Re: **Marysville Corporate Center – BSP (PA22004)**
2nd Round Response Letter
Project Number 2200444.00

In response to your plan review checklist dated September 19, 2022, we have addressed the items below, with our responses following your comments.

INDEX DATA:	SEC 28-33 T 31N R 5E WM
SURVEY FOR:	PACIFIC REALTY ASSOCIATES, L.P. 15908 47TH AVE NE MARYSVILLE, WA 98271
SNOHOMISH COUNTY, WASHINGTON	
SHEET 7 OF 13

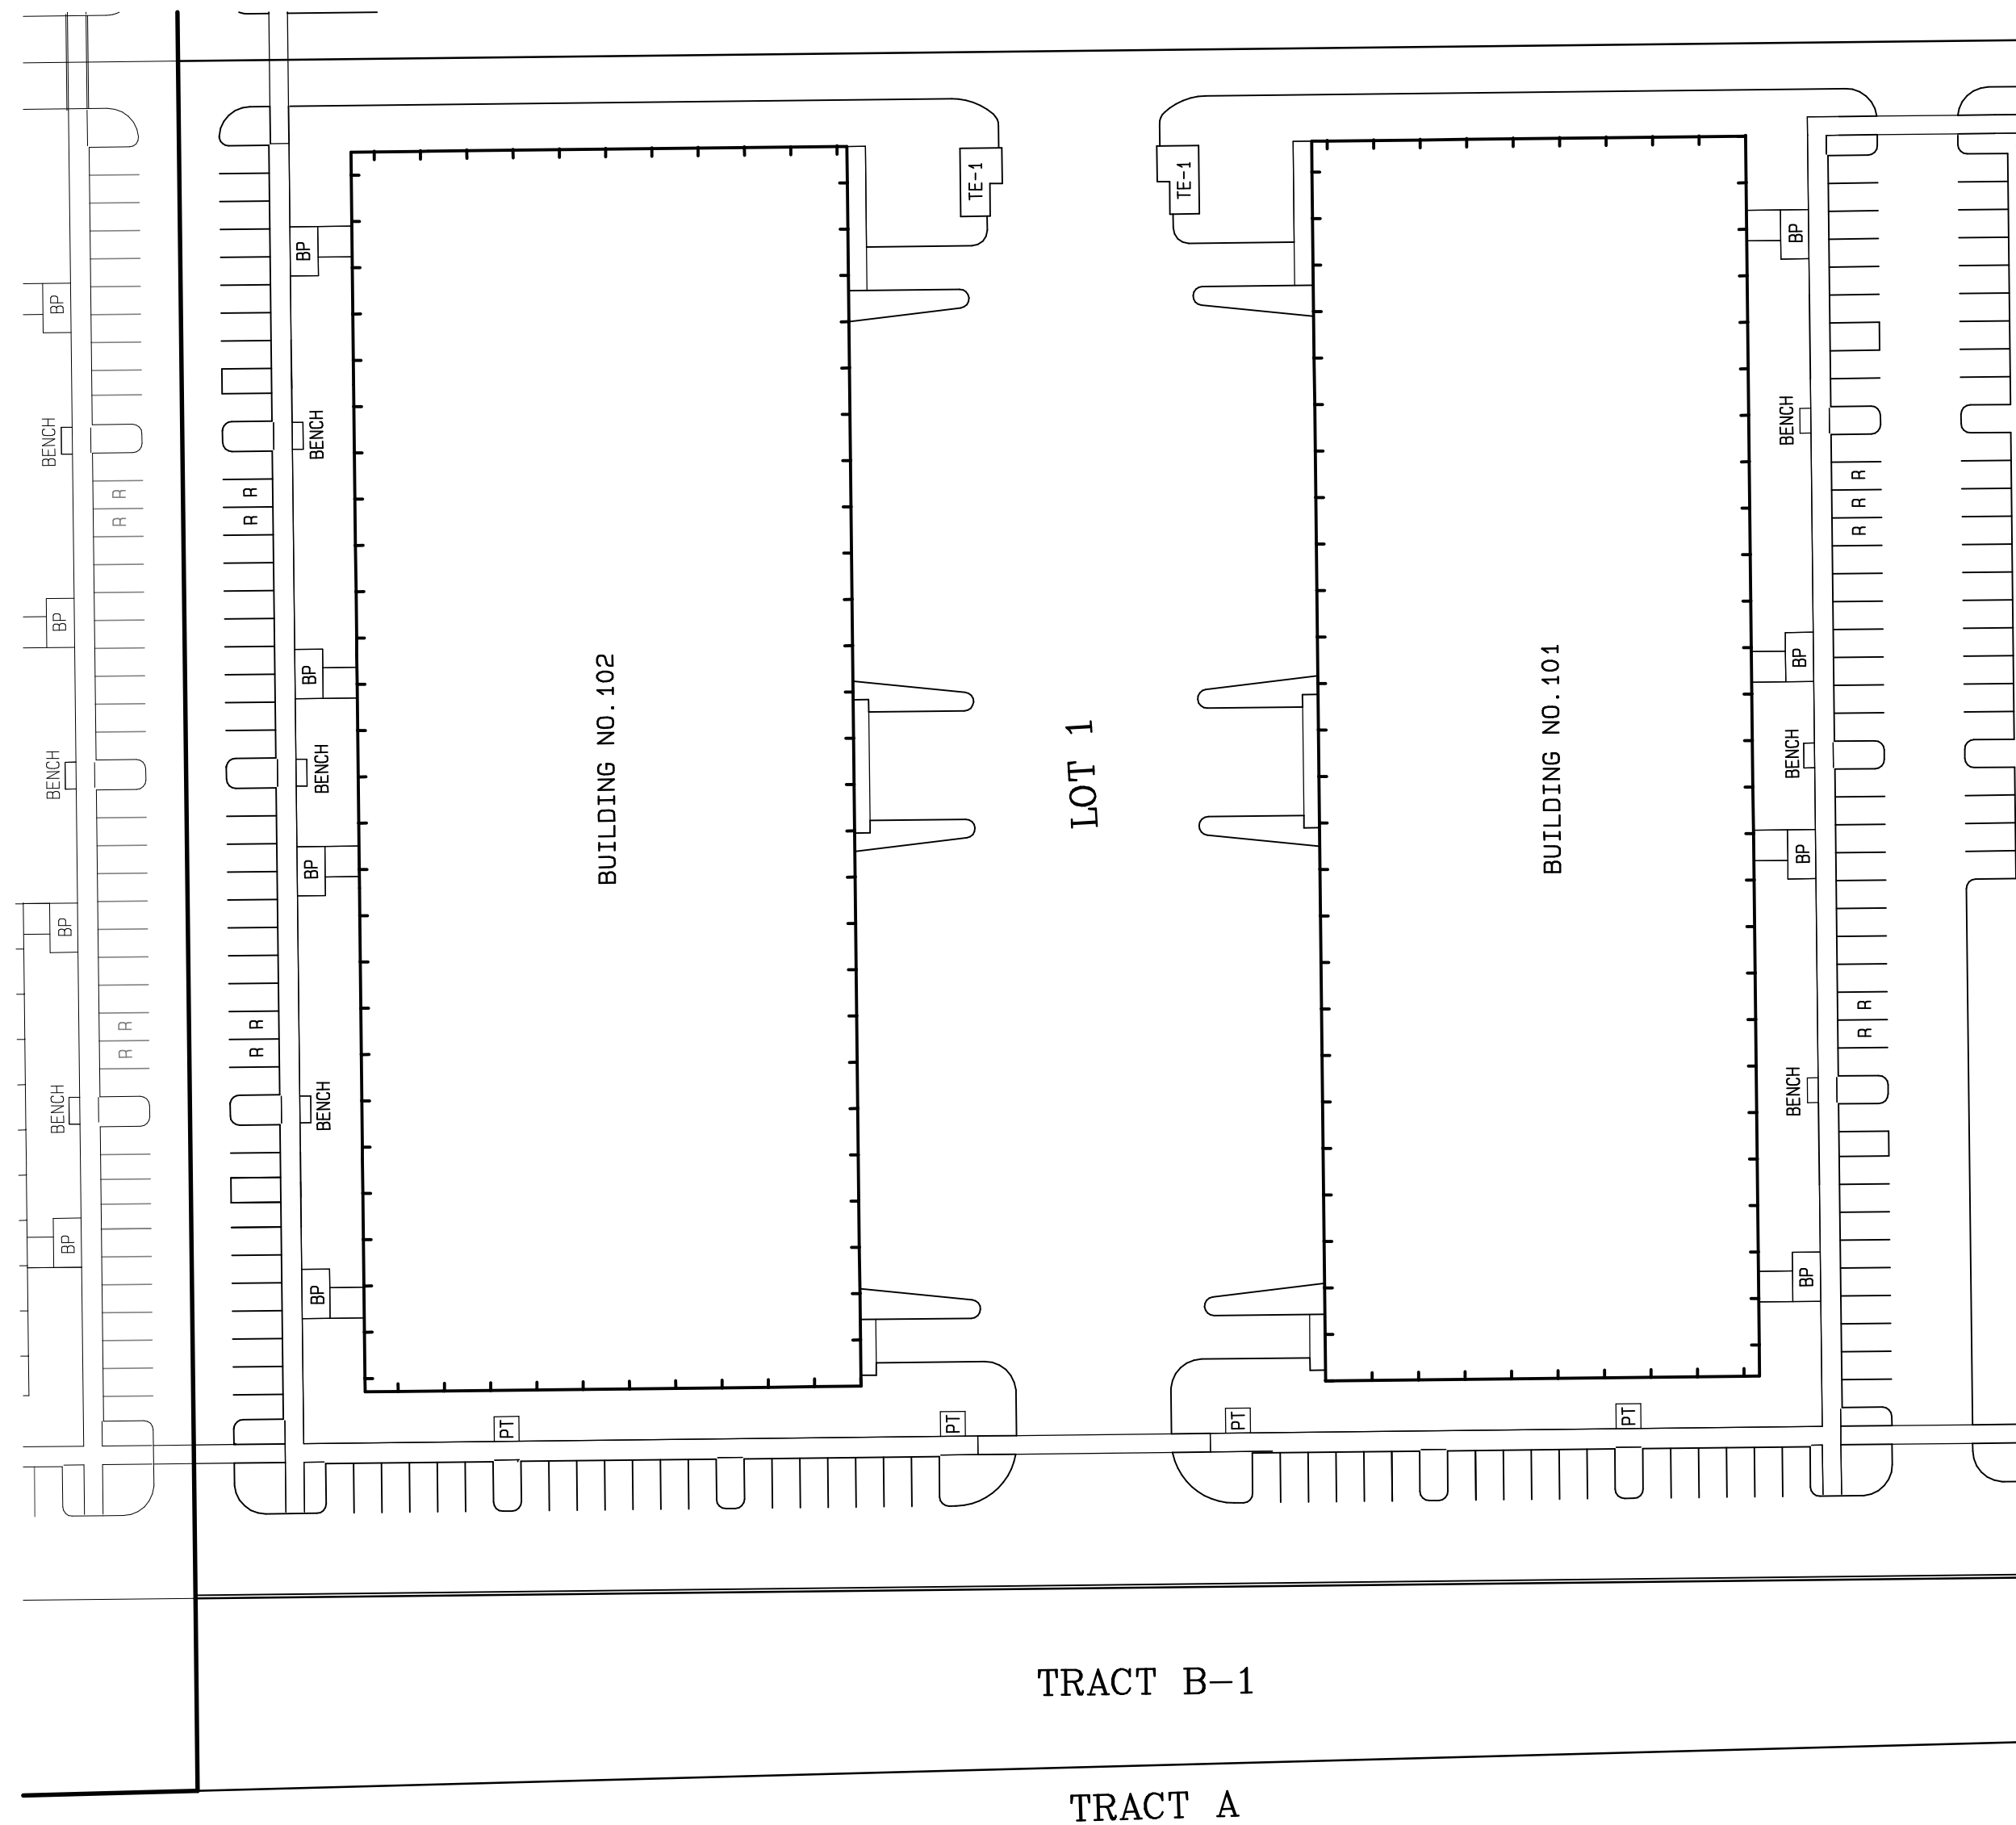
TR2 Comments: Provide the math for the required parking (including standard, carpool, ADA and bicycle), a detail of carpool parking signage, required parking stall dimensional standards, turning radii and auto turn as noted in the TR1 comments.

Response: The math for each buildings required parking is noted on sheet 7 and 8 of 13.
